Project #: 1010058 Application #: 14DRB-70226
14DRB-70225
 Project Name: BOSQUE PLAZA
 Agent: Darren Sewell Architects Phone #:

RE: KEN HURT OFFICE BUILDING
SITE PLAN FOR BUILDING PERMIT
AMENDMENT TO SITE PLAN FOR SUBDIVISION
BOSQUE PLAZA, LOT 5A
ZONE ATLAS PAGE E12

Darren Sowell Architects, llc on behalf of Ken Hurt, requests final sign-off of the amendment of the Site Development Plan for Subdivision and of the Site Development Plan for Building Permit for Lot 5A in Bosque Plaza.

The project will include a new office building for Ken Hurt on Lot 5A, Bosque Plaza, as shown on the Site Plan for Building Permit. The amendment request removes a 12 foot wide pedestrian/vehicle connection from Lot 5A.

**SITE PLAN FOR SUBDIVISION
 BOSQUE PLAZA**

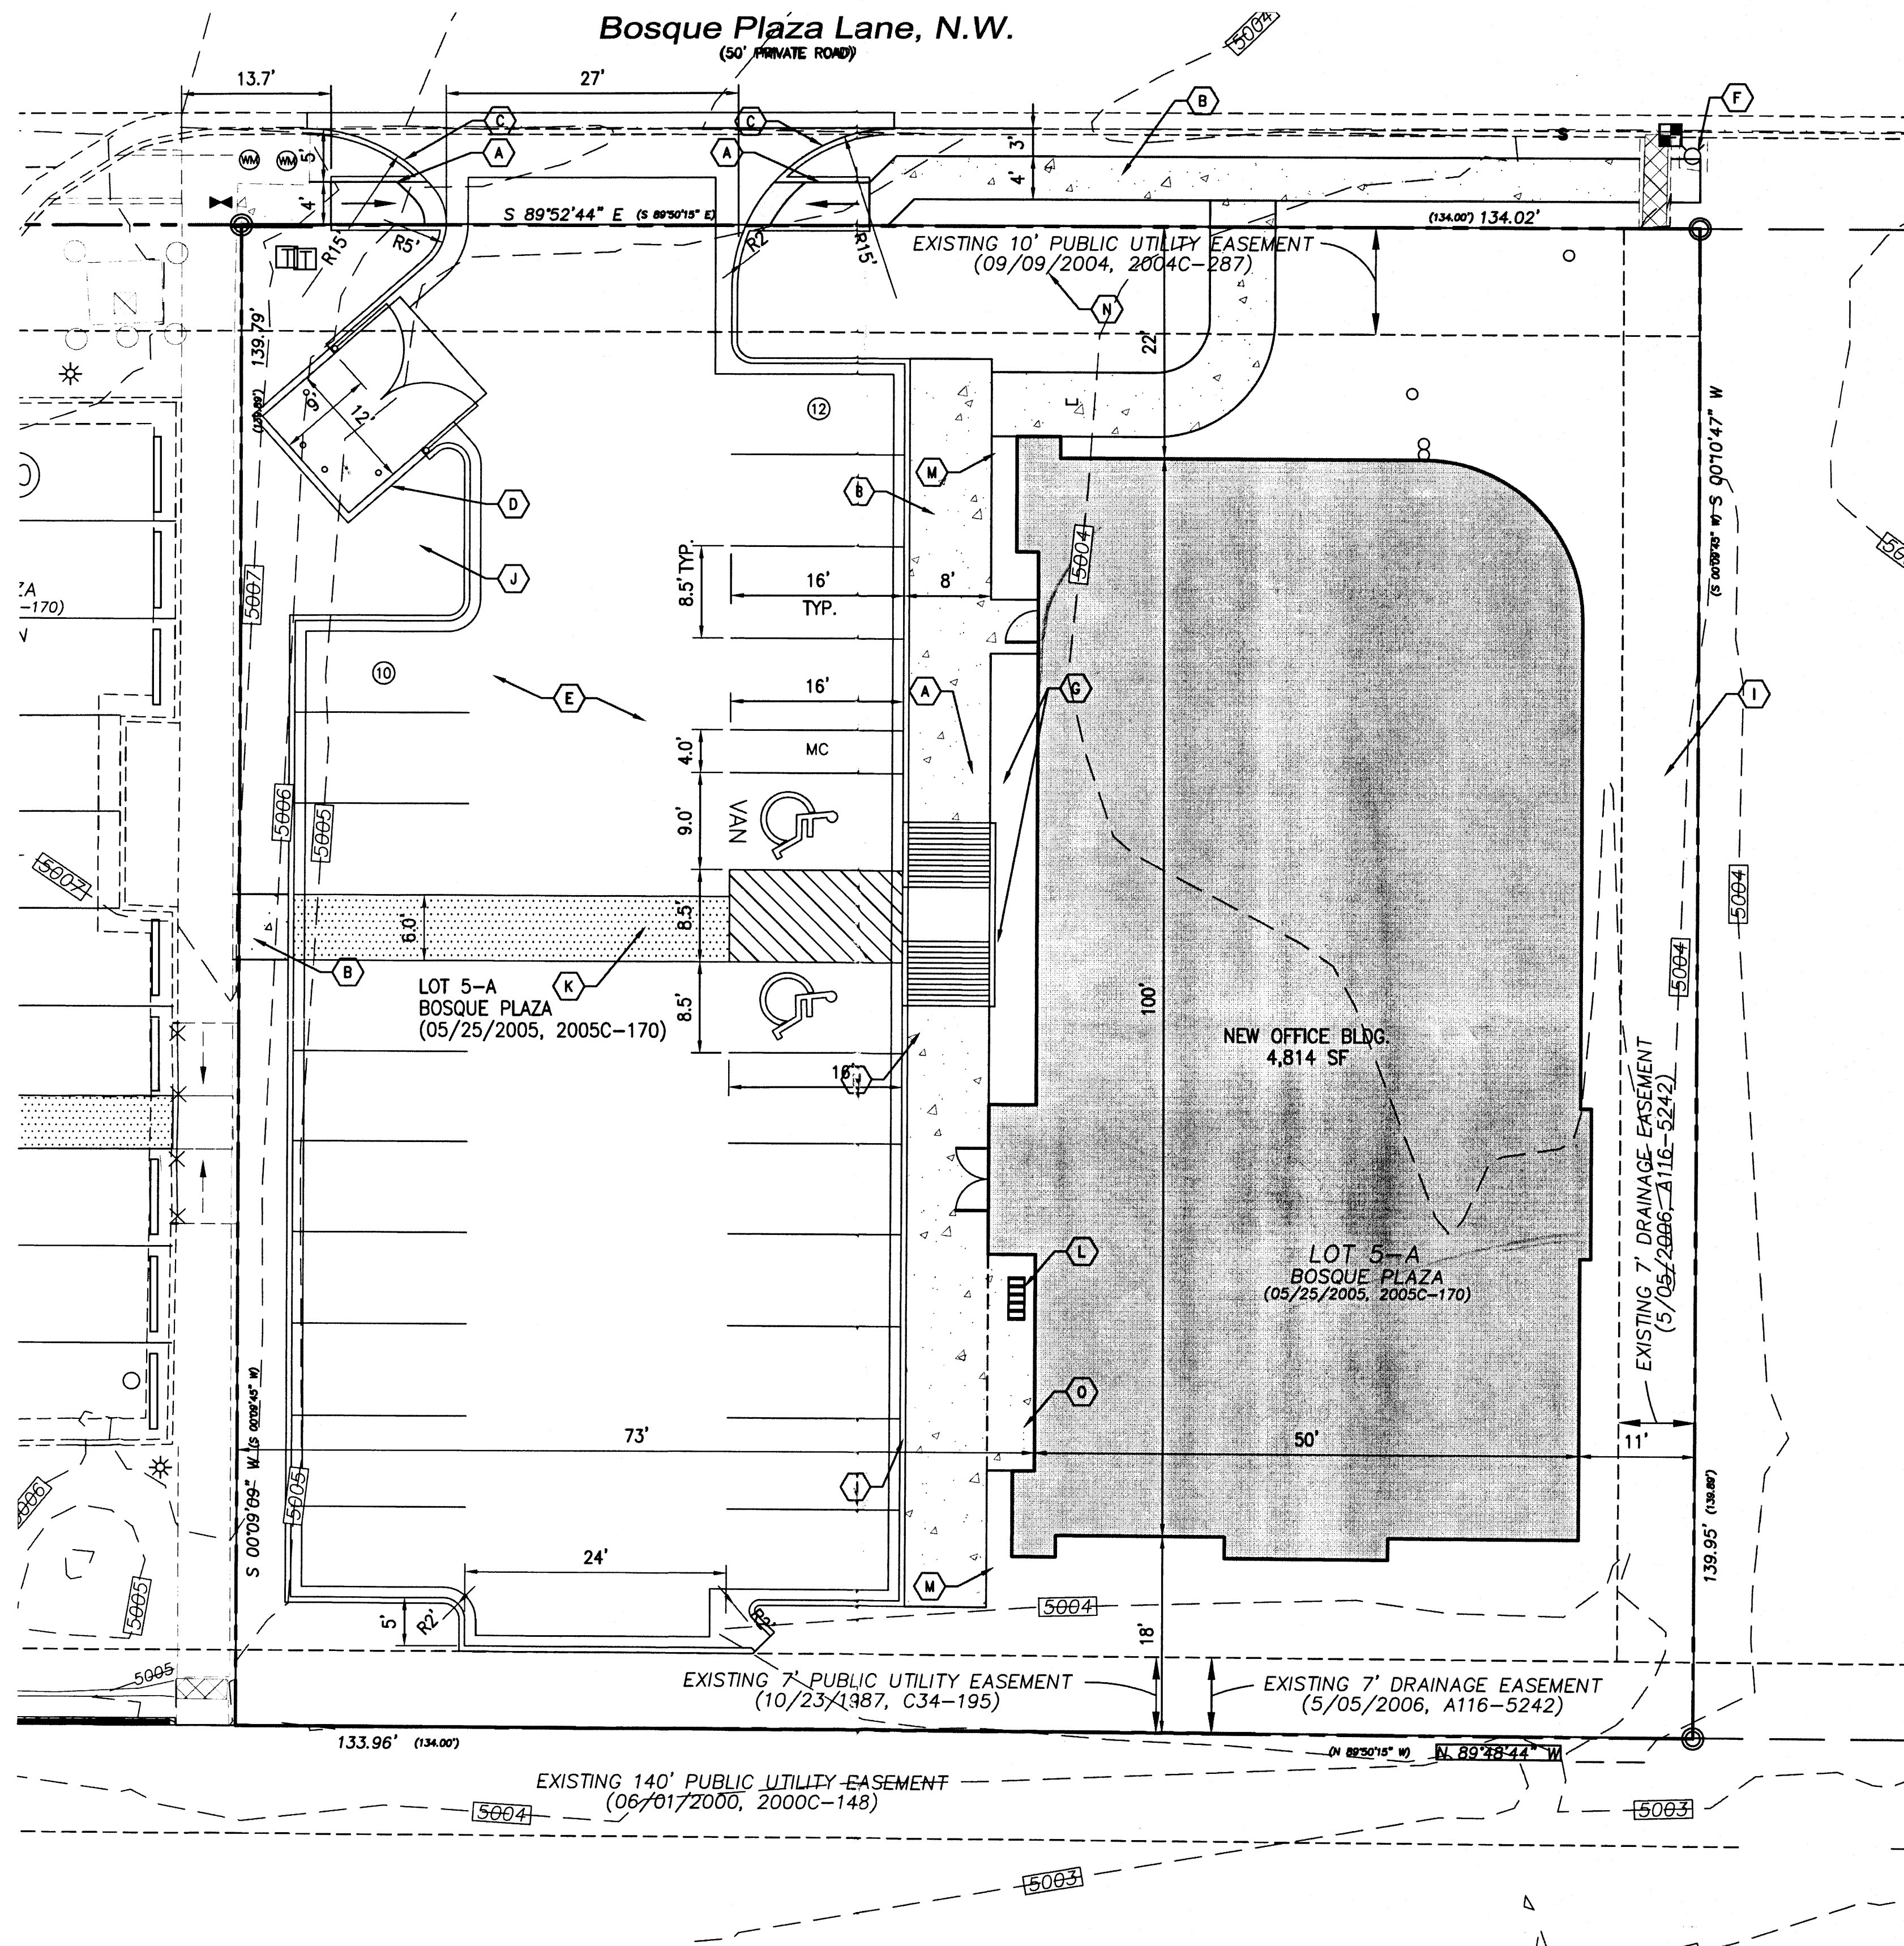
4. The Site Development Plan for Subdivision shall be amended to show the 12 foot wide connection on lot 4 only and remove the 12 foot wide pedestrian/vehicle connection from Lot 5A.

The note pointing to the 24' private vehicular/pedestrian connection has been altered from removal of the 24' connection to removal of the 12' connection from Lot 5A and the 12' connection on Lot 4 remaining.

AS001

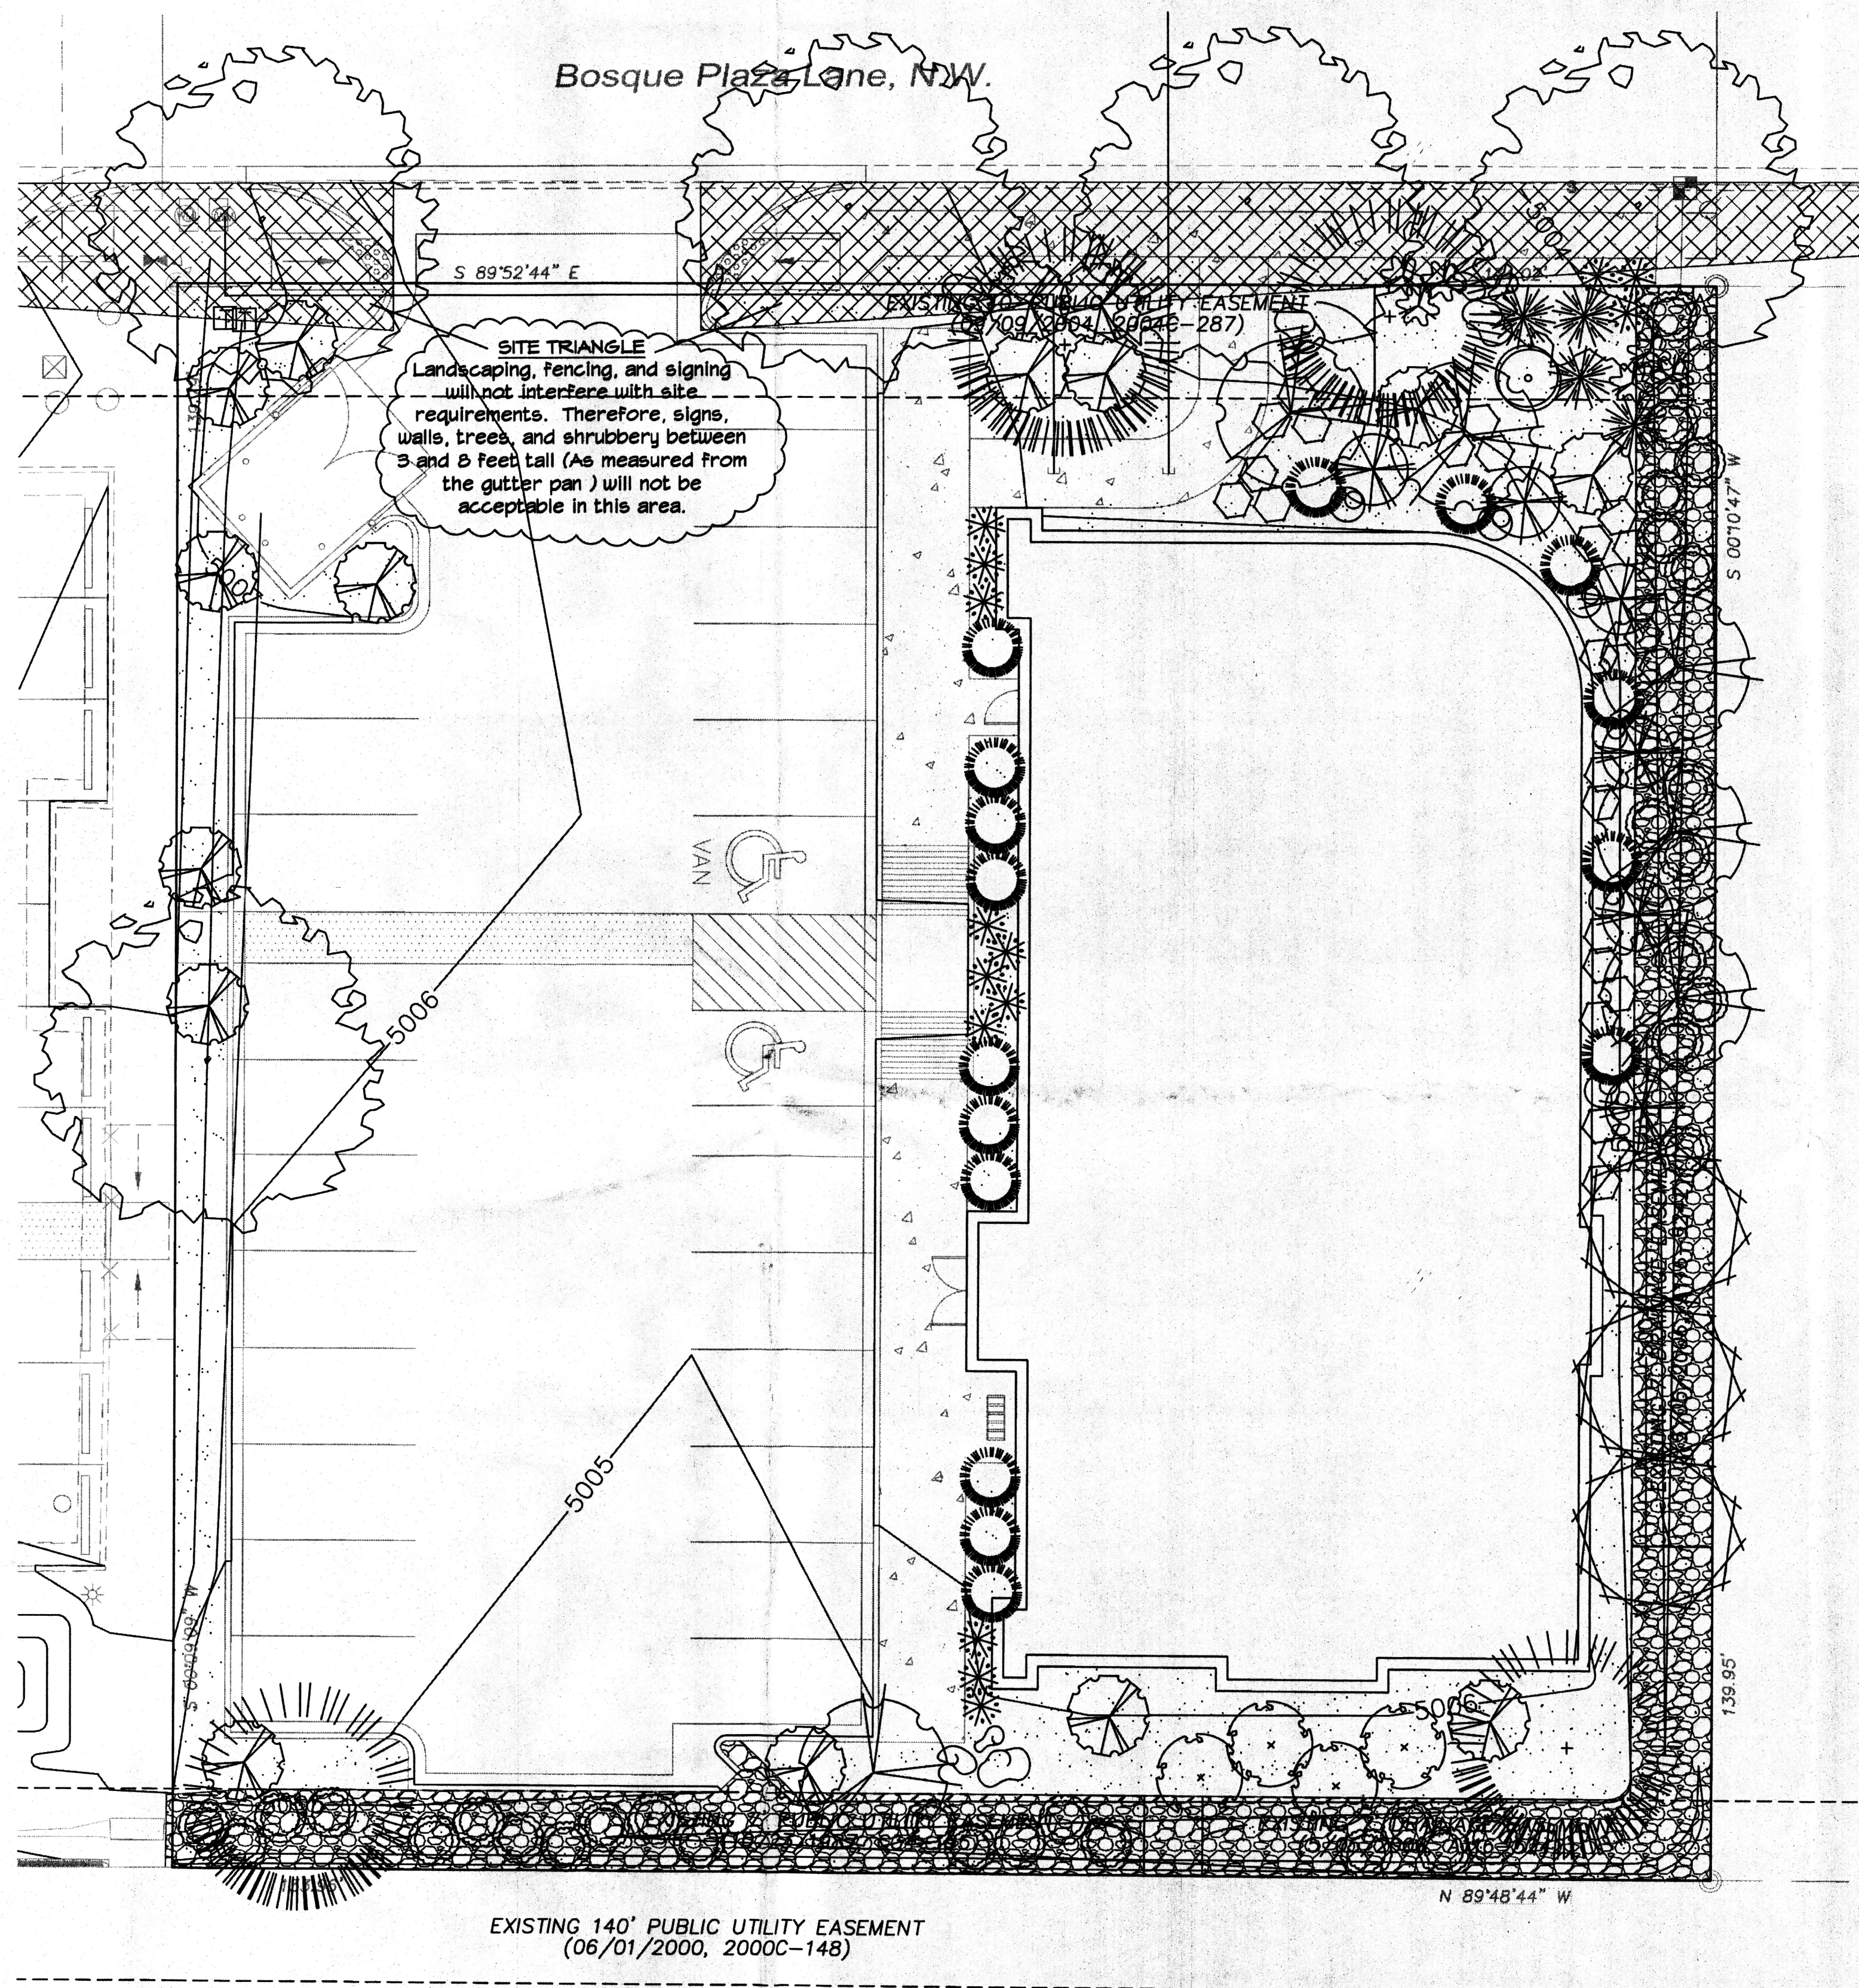
- a. The Developer is responsible for permanent improvements to the transportation facilities adjacent to the proposed site development plan, as required by the Development Review Board (DRB).

- b. Site plan shall comply and be in accordance with all applicable City of Albuquerque requirements, including the Development Process Manual and current ADA Criteria.

- c. Please add the following note to Site Plan for BP and Landscaping Plan:
"Landscaping, fencing, and signing will not interfere with clear sight requirements. Therefore, signs, walls, trees, and shrubbery between 3 and 8 feet tall (as measured from the gutter pan) will not be acceptable in this area."

- a. The applicant is responsible to determine if existing utility easements cross the property and to abide by any conditions or terms of those easements.

A note has been added under General Notes on Sheet AS001.

A note has been added under General Notes on Sheet AS001.

A note has been added under General Notes on Sheet AS001. Also, a similar note on the Landscape sheet has been deleted and replaced with this verbiage.

A note has been added under General Notes on Sheet AS001.
